**RE: STRATFORD EXTENSION PROJECT (SSD-4966)  
EXHIBITION OF ENVIRONMENTAL IMPACT STATEMENT**

**Re: Comments to the Proposed Extensions to Stratford Coal Mine, Gloucester (SSD-4966)**

SUBJECT Stratford Coal Mine Extension - SSD - 4966

Figure 1: Location of Stratford Biodiversity Offset Areas

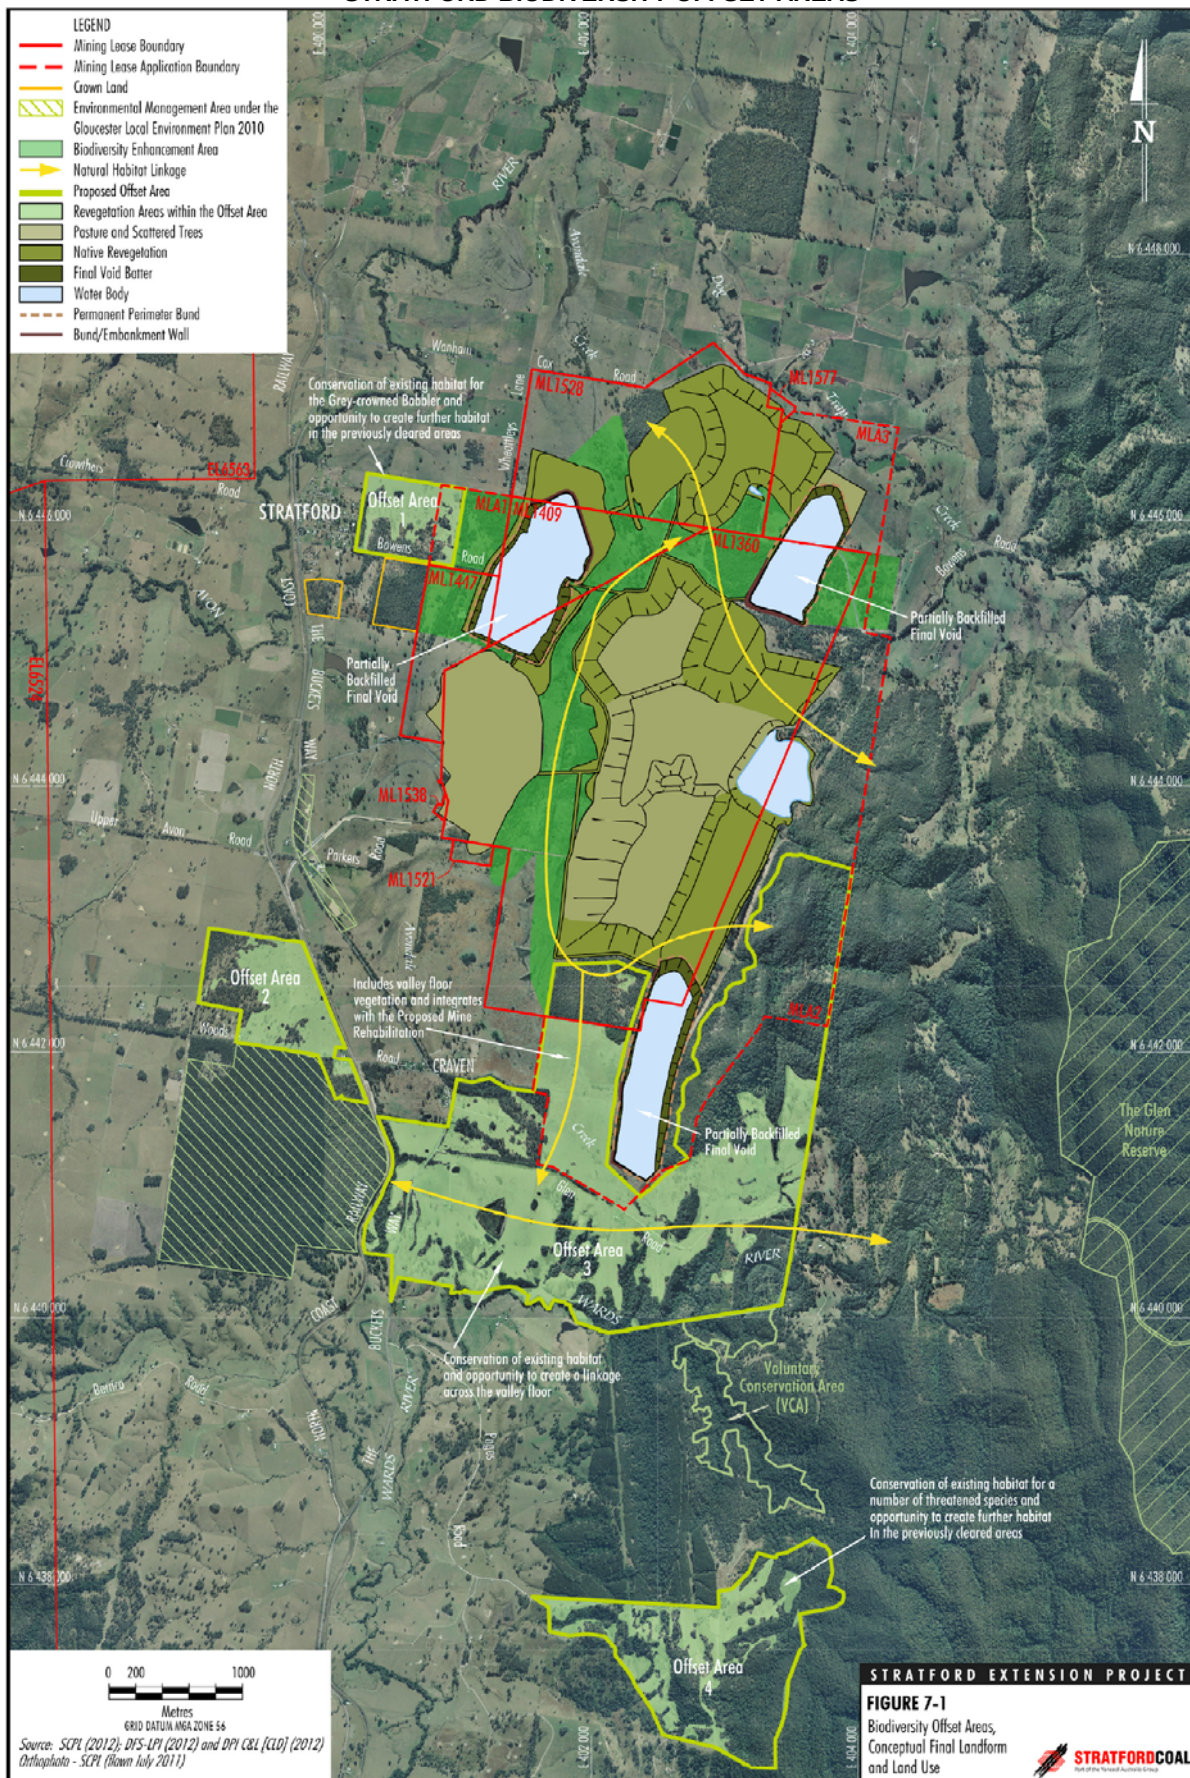
In particular, I would reiterate concerns relating to the spatial location of the offset areas nominated in the EIS and the paucity of detail reflecting that offset areas will be effectively secured in proactive, in-perpetuity conservation.

It is not reasonable to proffer an apparent offset area to deal with biodiversity impacts that contains: dwelling-houses, proposed new electricity easements and future gas wells associated with coal seam gas extraction. To proffer such discredits the ability of the offset area to provide for meaningful compensation for the ecological effects of the development and undermines public perceptions as to the meaningfulness and credibility of the offsetting and biodiversity protection processes.

Thus, offset areas must be appropriately located, secured in a timely, effective manner, proactively managed for biodiversity restoration and conservation and maintained in-perpetuity. The proposal appears to fail to deliver adequate offsets in terms of location and effectiveness of conservation mechanism and actions. Novel approaches to effective conservation should be further explored (eg. public dedication of the conservation area with the provision of funding for conservation and restoration, combined with agency and conservation NGO partnership for the long-term management of the offset areas). This issue must be addressed through the consent process, should the proposal be positively-determined.

The shape and spatial location of the final offset areas must be devised to reflect cumulative ecological restoration aspirations that are practical and effective. To a degree, the existing offset areas appear to be defined through convenience rather than outcome.
